I am writing regarding planning application No 3/2021/0731

I am opposing the redevelopment and building of new infant block with additional carparking at St James C of E school, Greenacre Street, Clitheroe BB7 1ED.

**Petition against the proposed amended 2023
plan building of infant block at St James' C of E
school, Greenacre street, Clitheroe, BB7 1ED**

Planning ref number 3/2021/0731

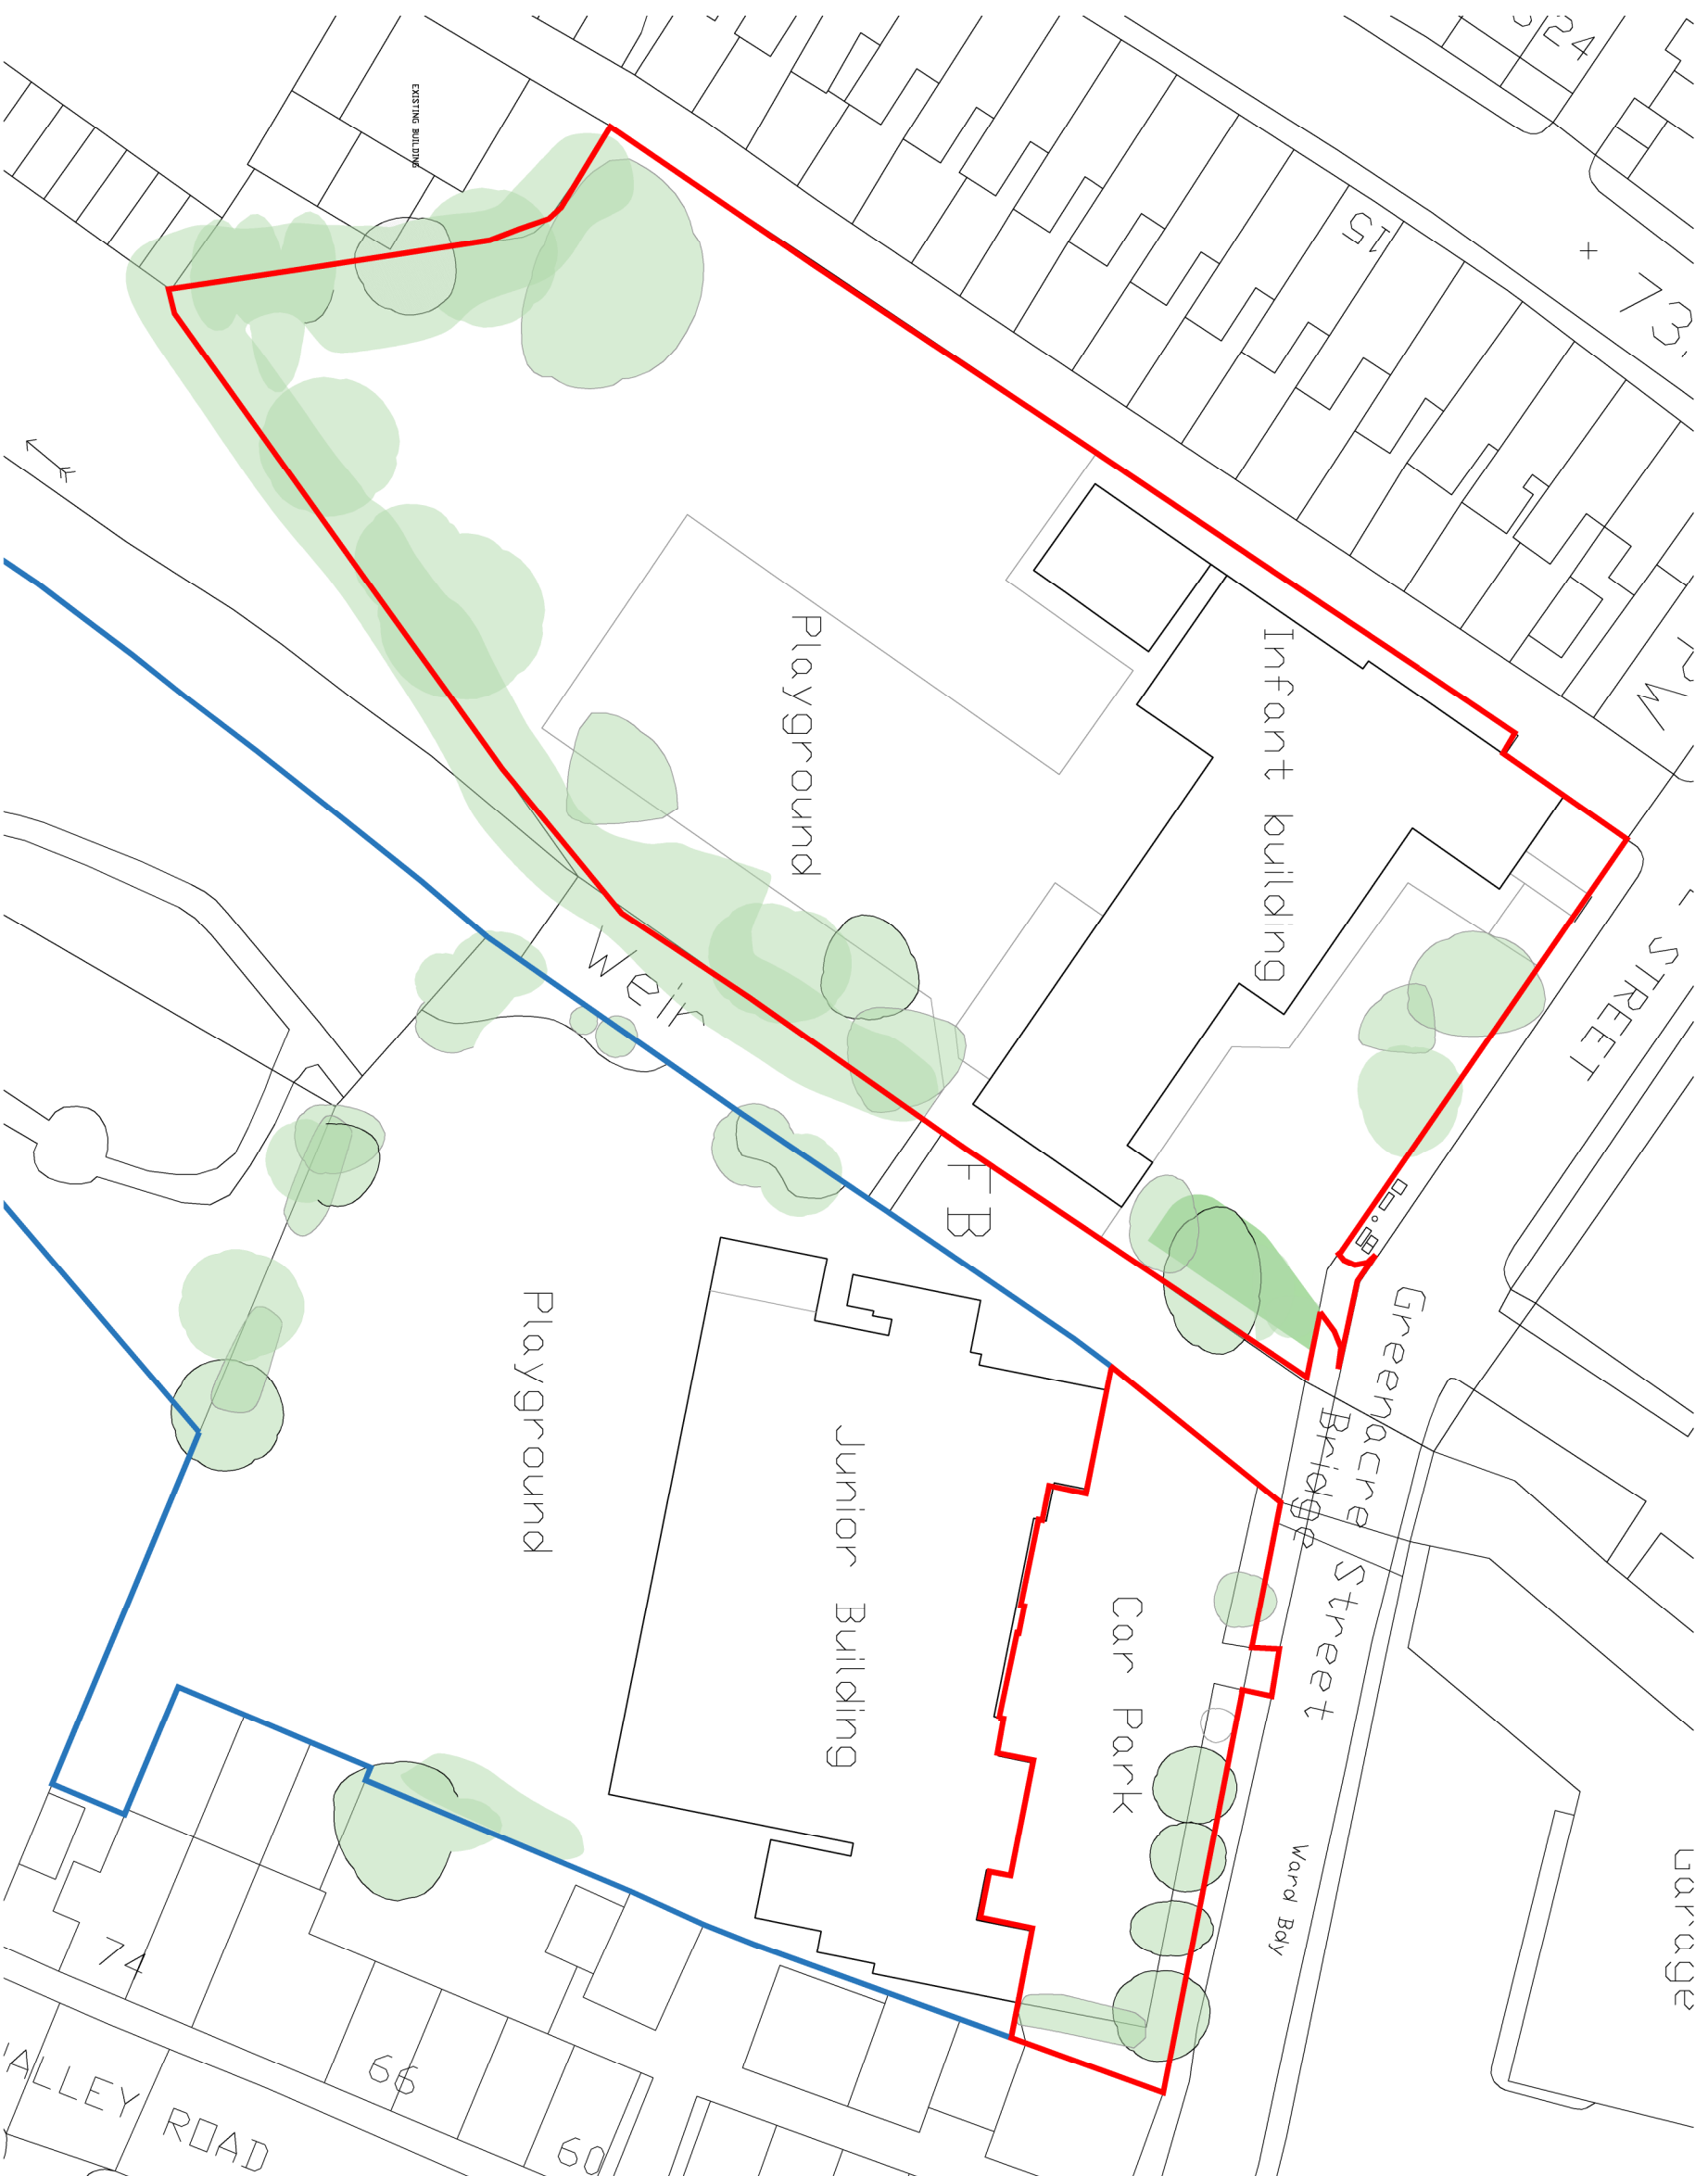
Currently there are 16 parking spaces with one exit/entrance. The Highways Agency have 26 parking spaces in their report.

The amended application states there are currently 19 spaces with the proposed number of 20 spaces when work is completed. The current site plan on application the records is 16 spaces, and the most up to date plan has 19 spaces.

There are 16 spaces with one exit and entrance currently. The amended plan shows 19 spaces. The Highways Agency seem to have the number as 26 spaces.

The application on 19th Sept 23 states there are currently 19 parking spaces, and the proposed number is 20 spaces. The current site plan on your records shows 16 spaces, and the most up to date plan has 19 spaces.

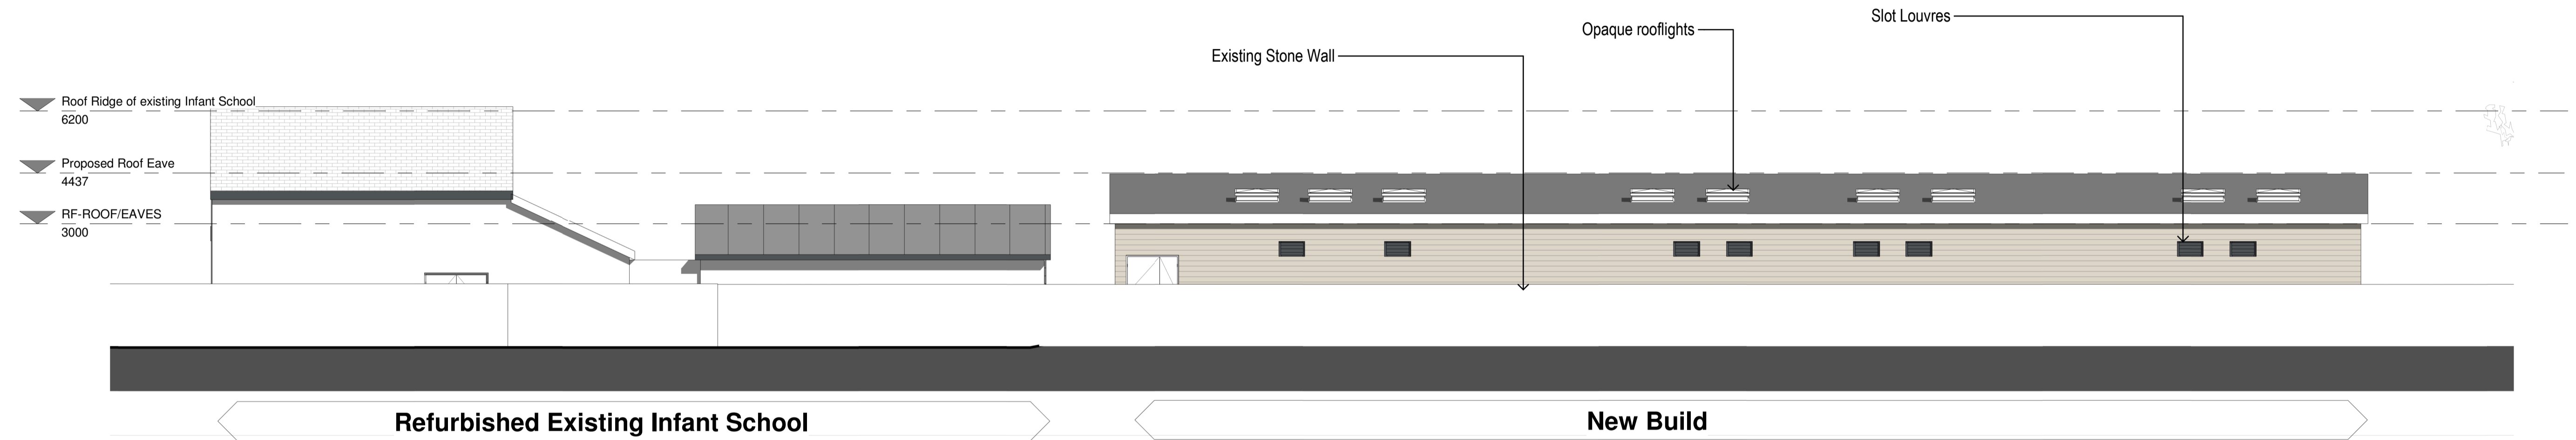
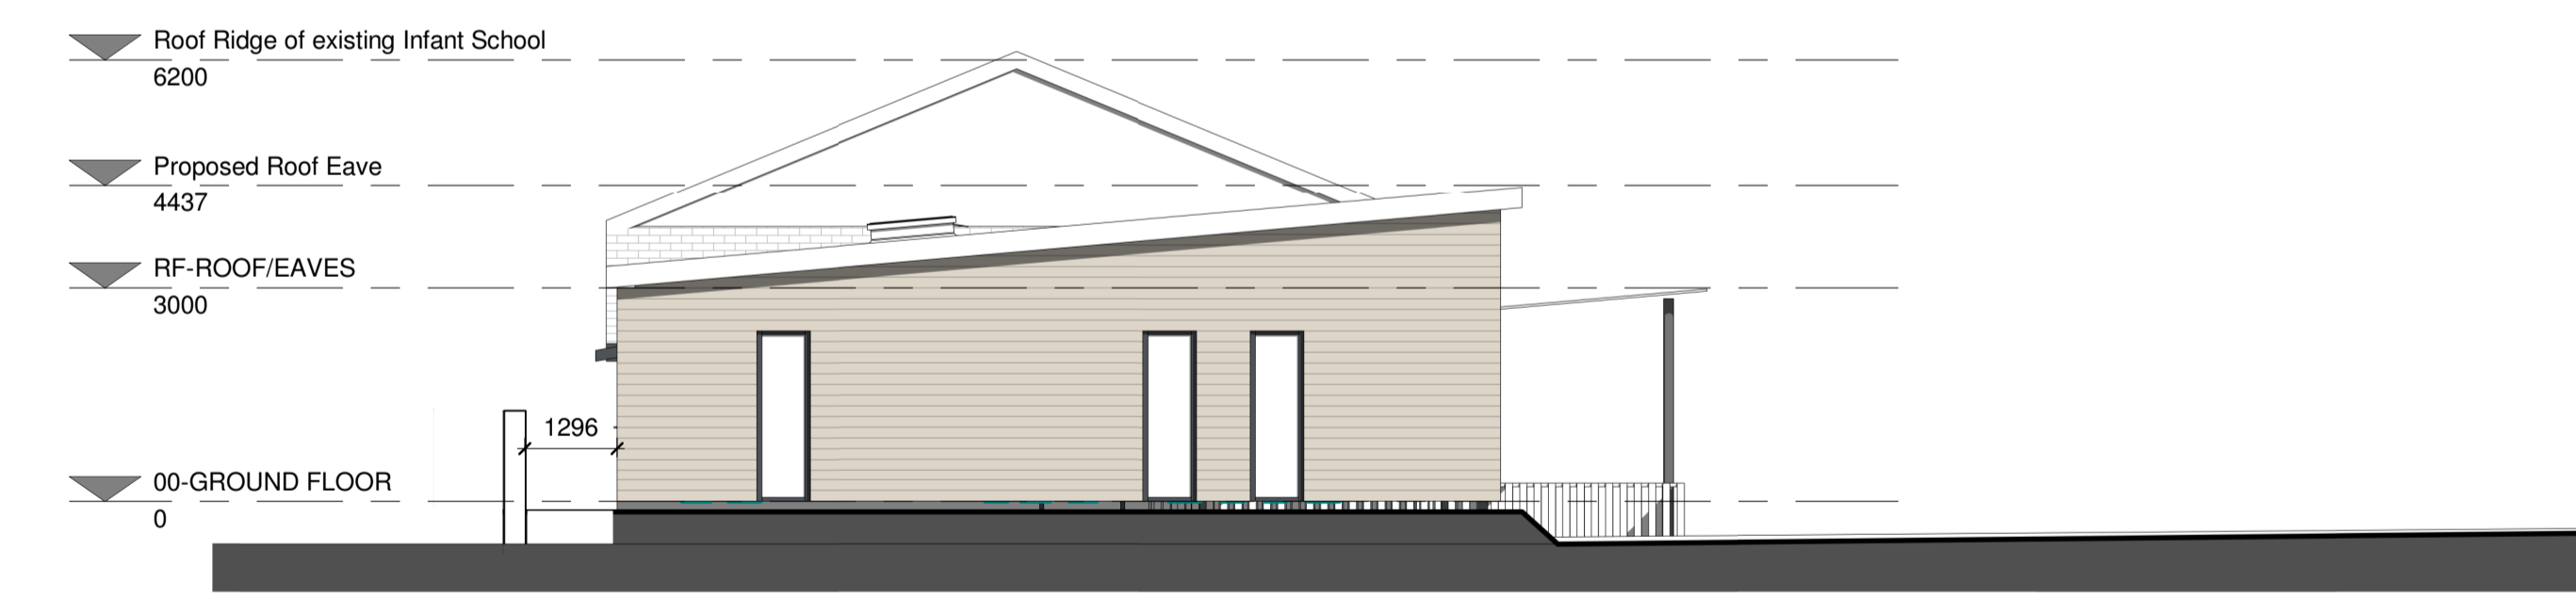
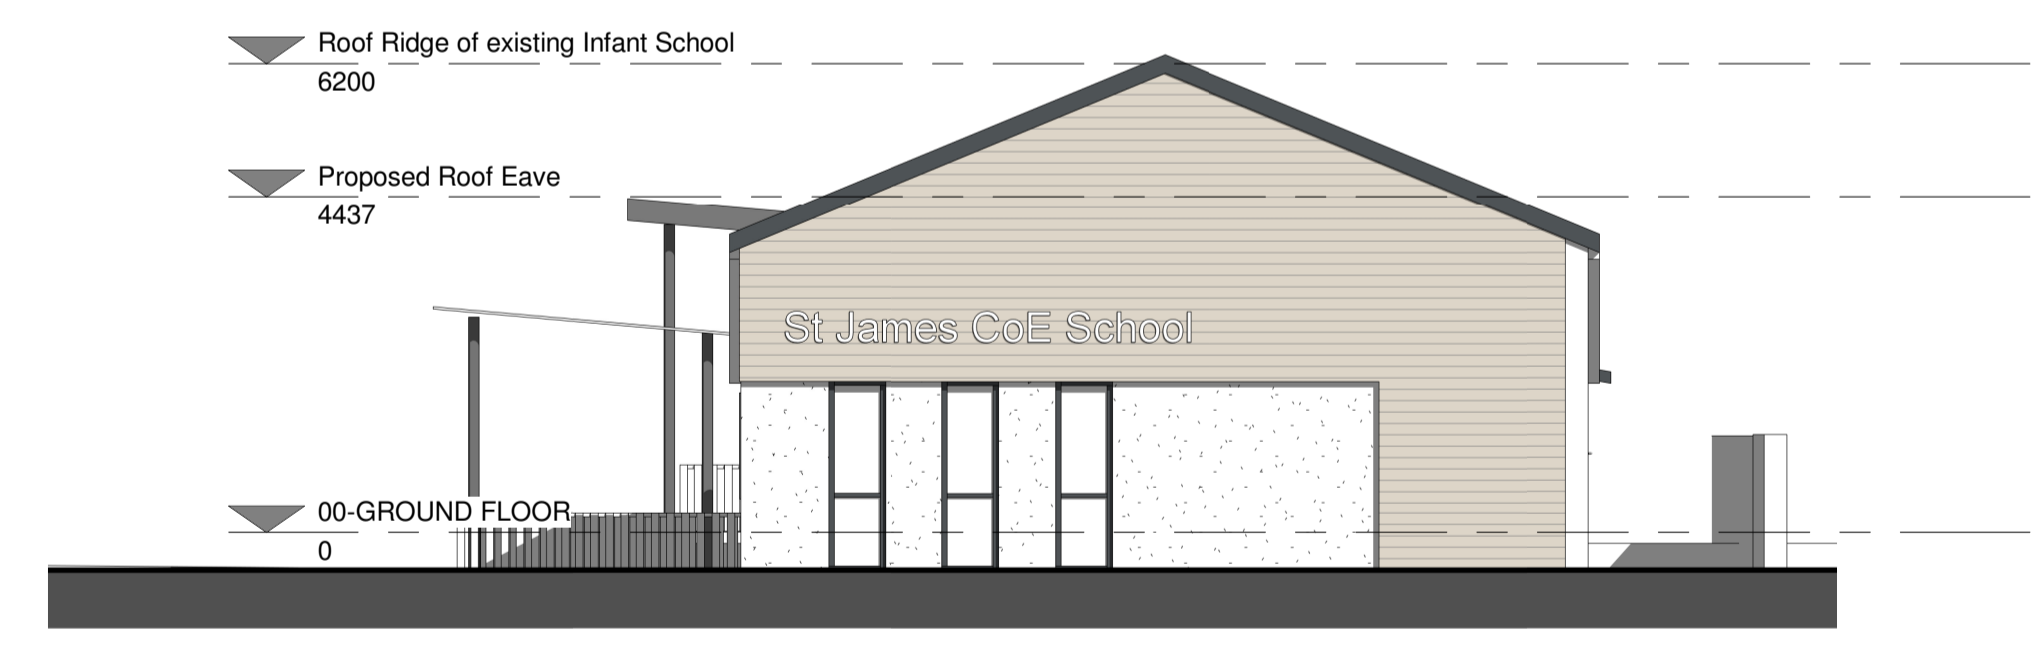
The proposed new infant building is on the plans to be an expected 42 meters in length and 4.5 meters high, this will be a huge building in length and height – the height is closer to the kitchen roofs of the 2 bed terraces on this block. It states it is supposed to be a one-story building

The proposed new infant building is described as cedar wood cladding and metal roof – this is not in keeping with the surrounding properties which are stone.

The proposed new infant building is ESTIMATED to be 42 meters in length and 4.5 meters high –this is a very large building both in length and alleged height – the height is closer to 2 stories not one. Proposed and result are two very different things.

The proposed new infant building is described as clad with treated cedar wood and metal roof –this is hardly in keeping with the surrounding properties built from stone and the heritage site adjacent. It will look like an oversized garden shed!

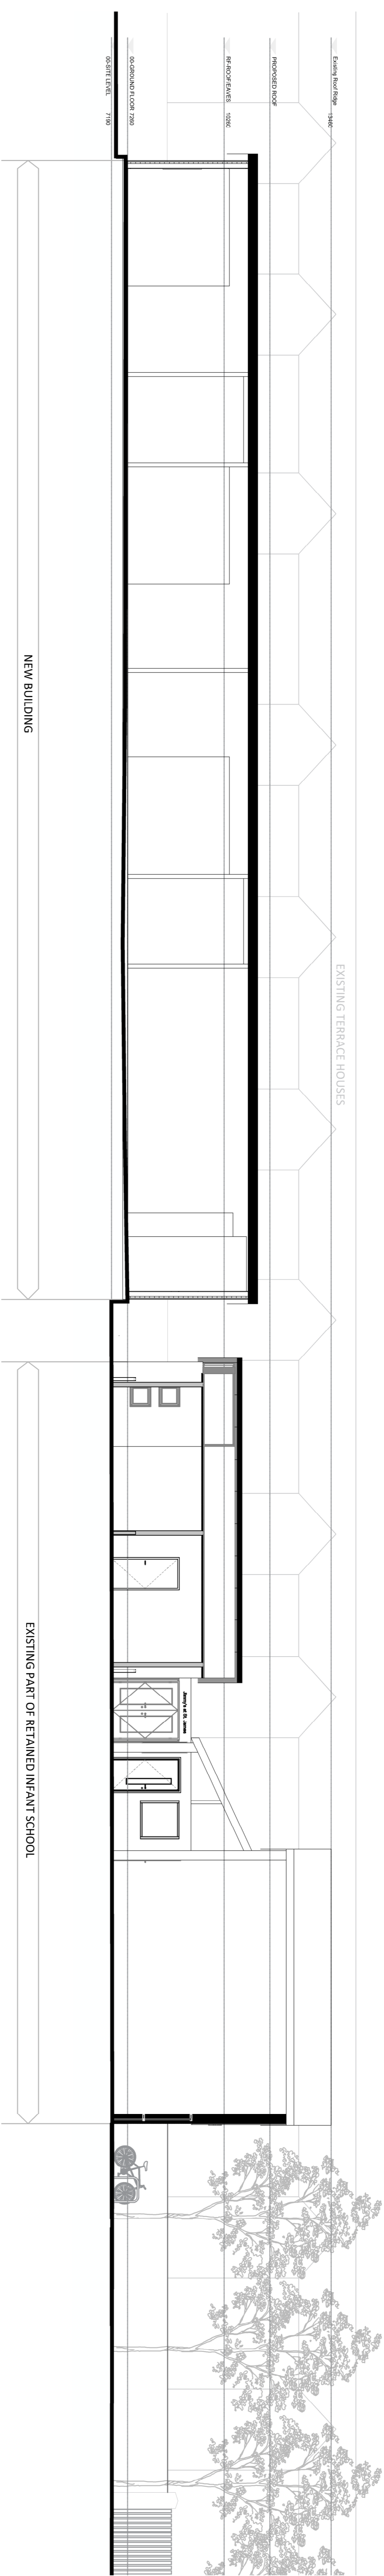
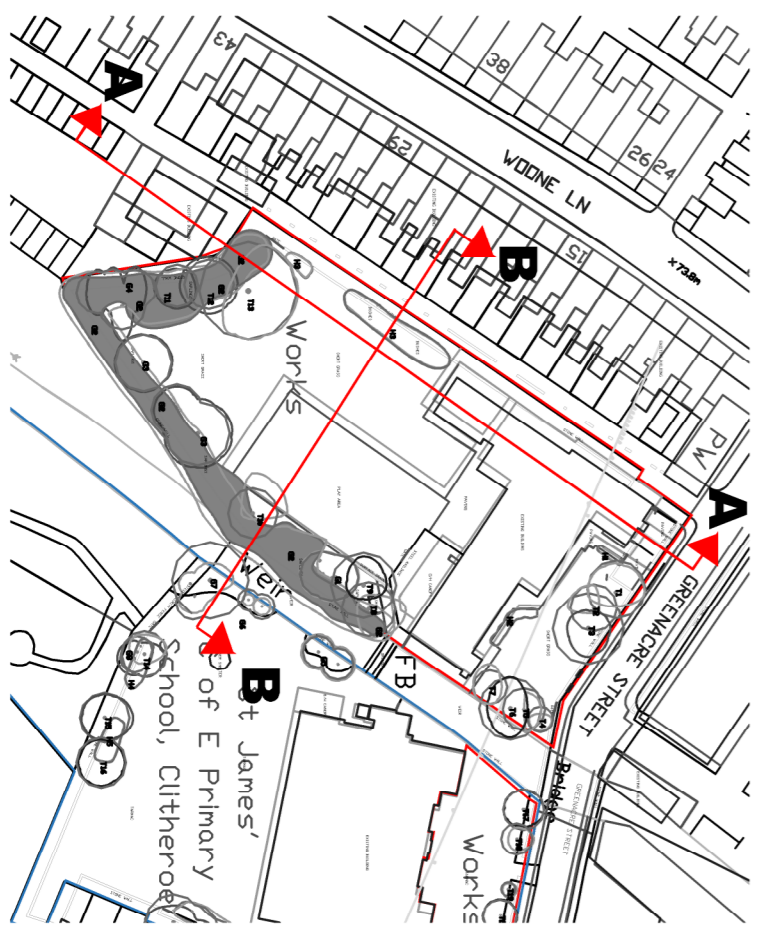
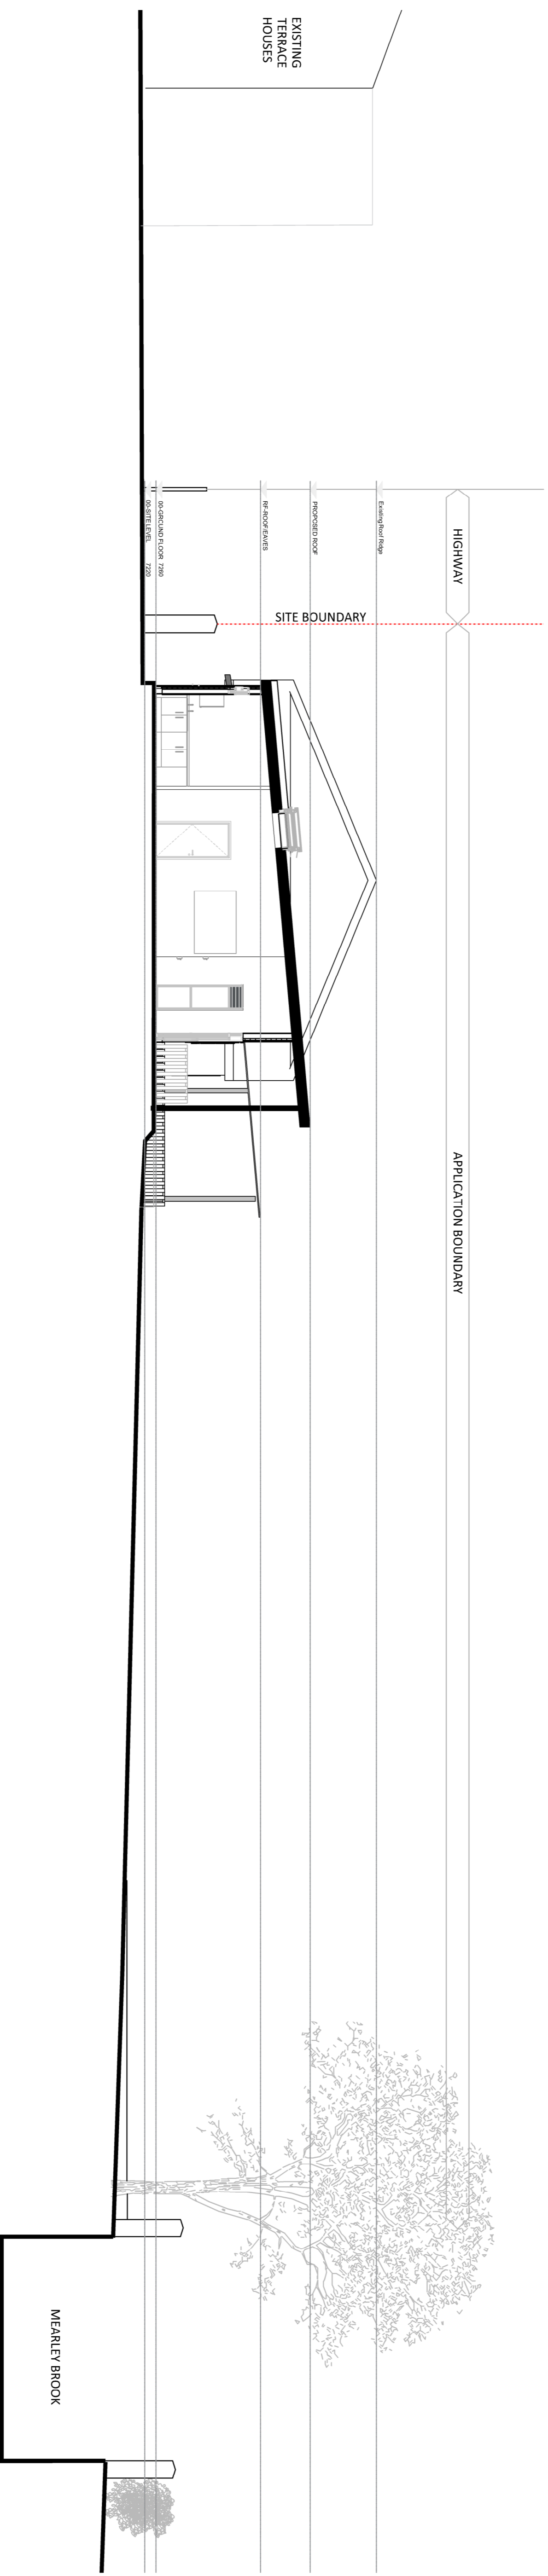
If in the event of a fire at the school the risk to the safety of residents, and adjacent properties from radiated heat, building collapse and the spread of fire to Woone lane is very high due to the proposed proximity of the new infant block –it is 12 feet or in metric 3.6 meters from the boundaries of the neighboring houses. In addition, there will be restricted access for emergency service personnel, emergency vehicles and firefighting equipment.
